**Rampion 2 Offshore Wind Farm (Project Reference: EN010117)**

**Deadline 3 Submission (25 April 2024)**

**West Sussex County Council (IP Reference 200445228)**

## **Oakendene onshore substation - Indicative Layout and Elevation**

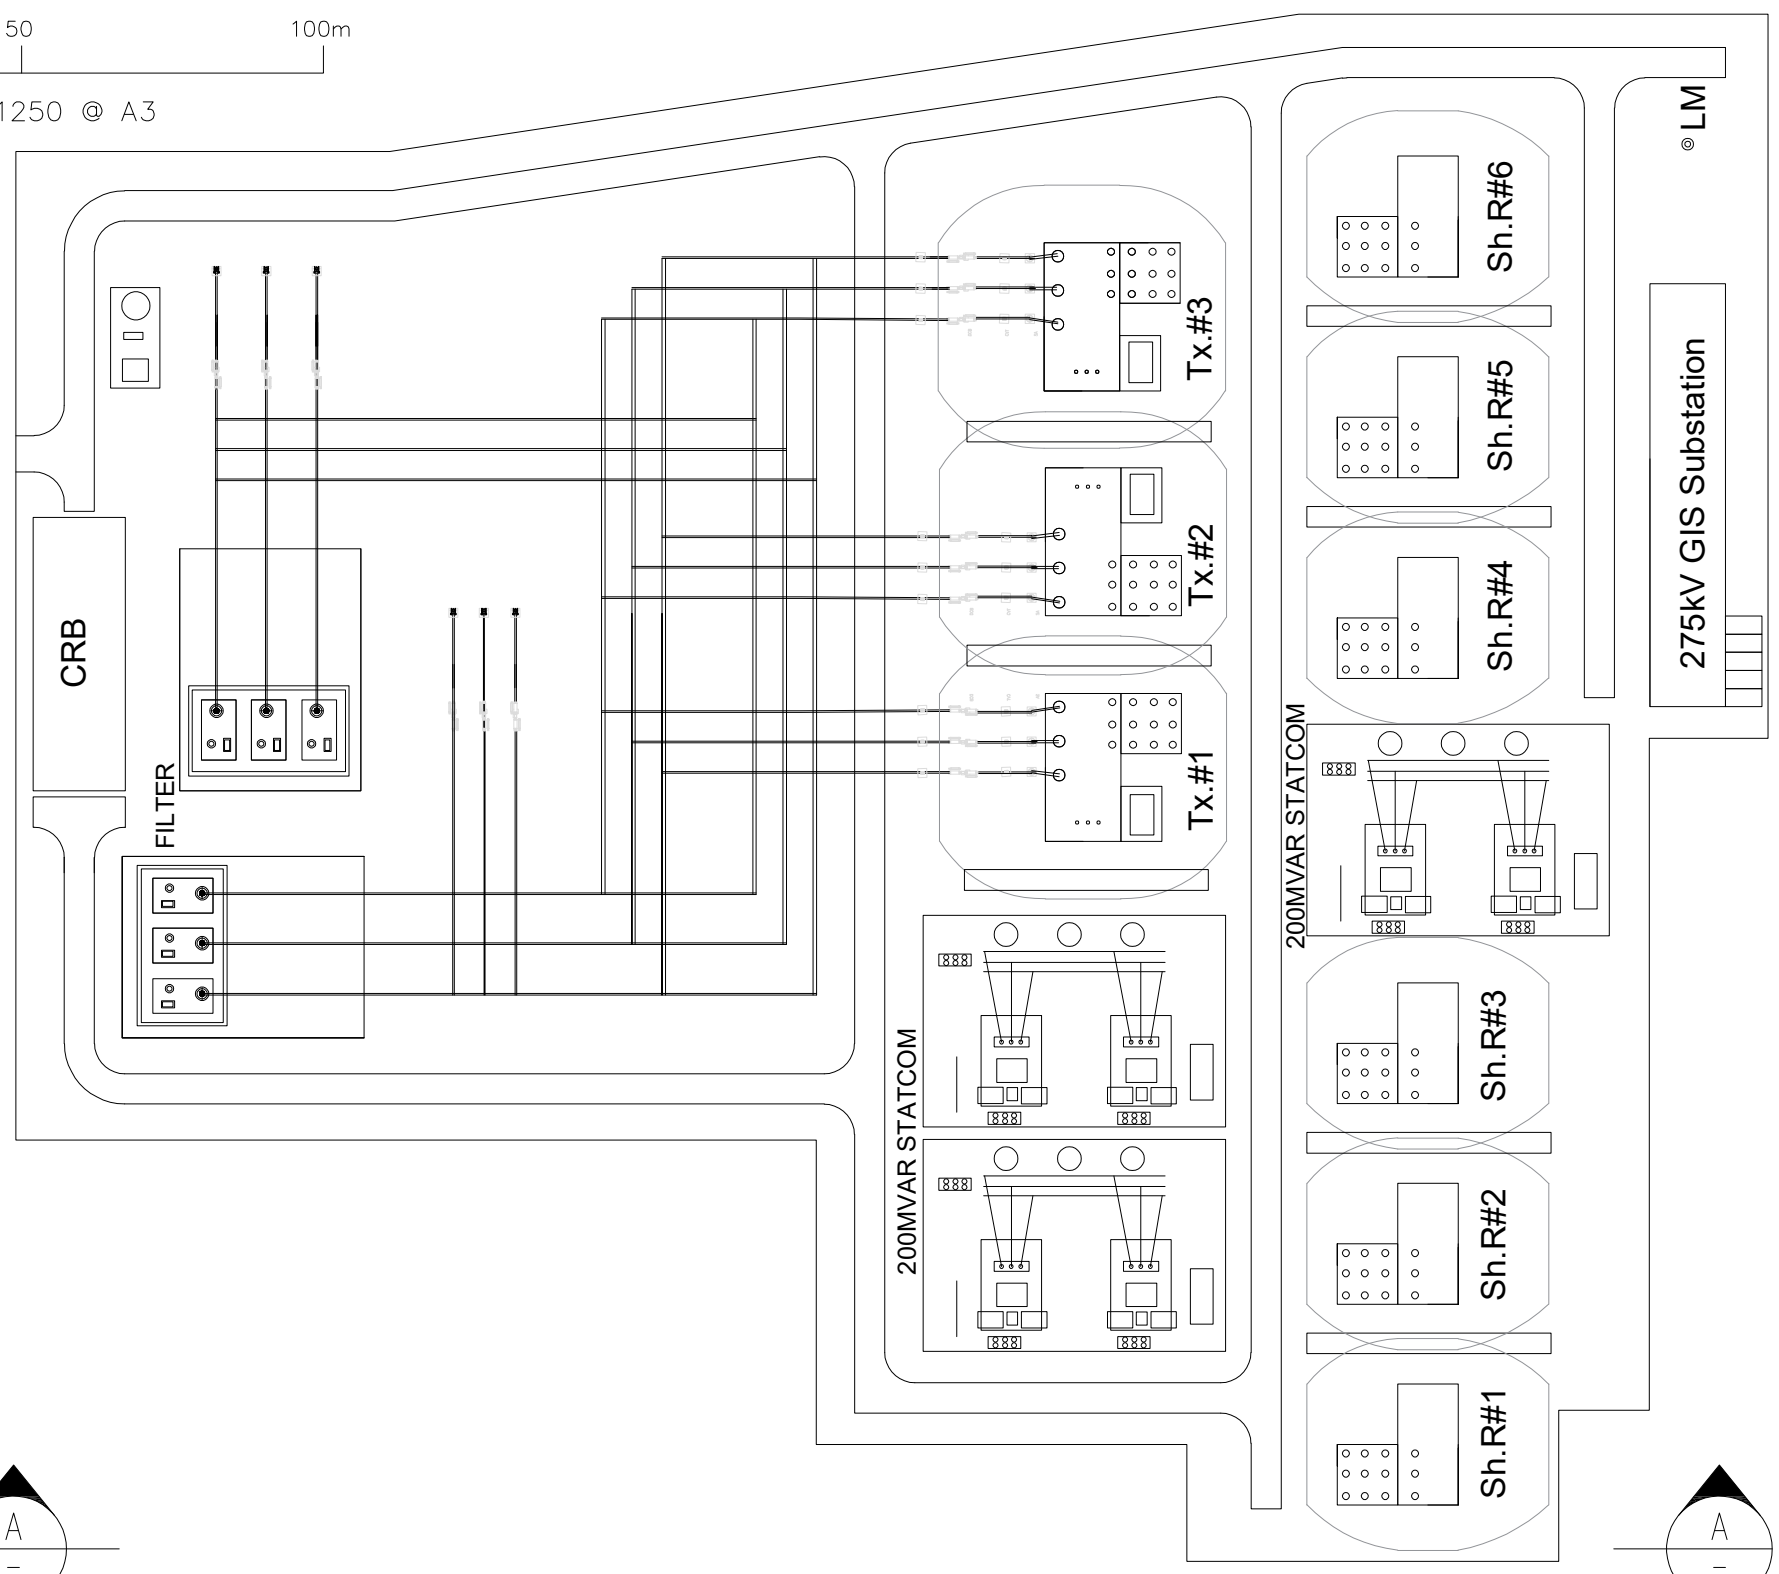
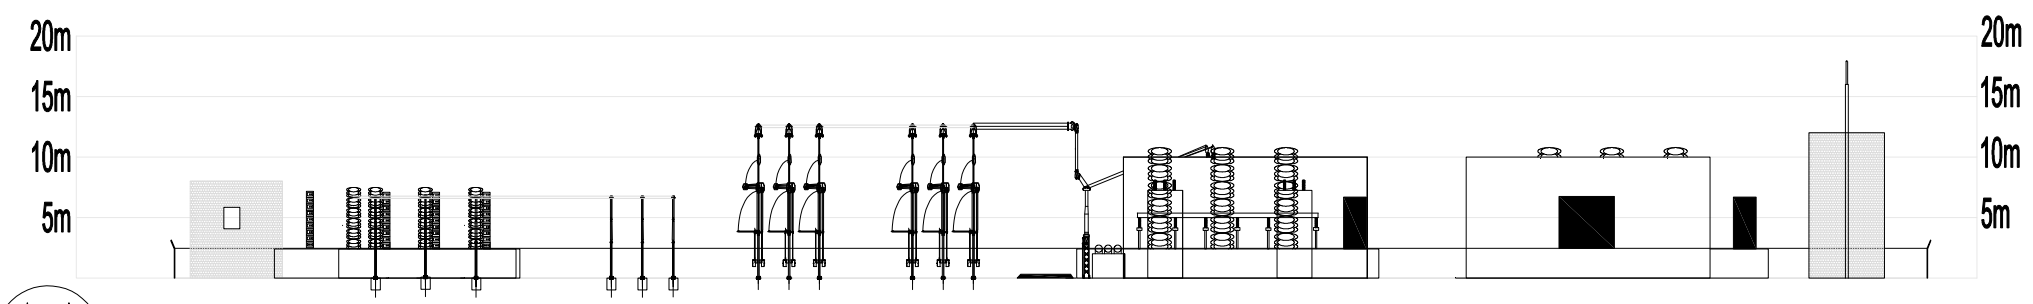
welcomed. WSCC also highlight that corresponding visualisations will need to be provided at any new VPs, and for those at the onshore substation, these should include the 18m lightning mast. As the tallest feature on site, WSCC do not agree that the lightning mast would have limited visual impact and would not contribute towards significant visual affects as stated by the Applicant in response to 9.68.

- 2.40 Details of existing and proposed site levels at the substation remain unclear. The Applicant's response to 9.70 provides little, if any, clarity on the matter. As previously noted, given a slope is present on the site and that all maximum heights for plant/structures are based on 'finished' ground levels, it is crucial to understand the extent of any cut and fill operations and likely final site levels. Any substantive change in site levels could result in significant changes to landscape and visual impacts.
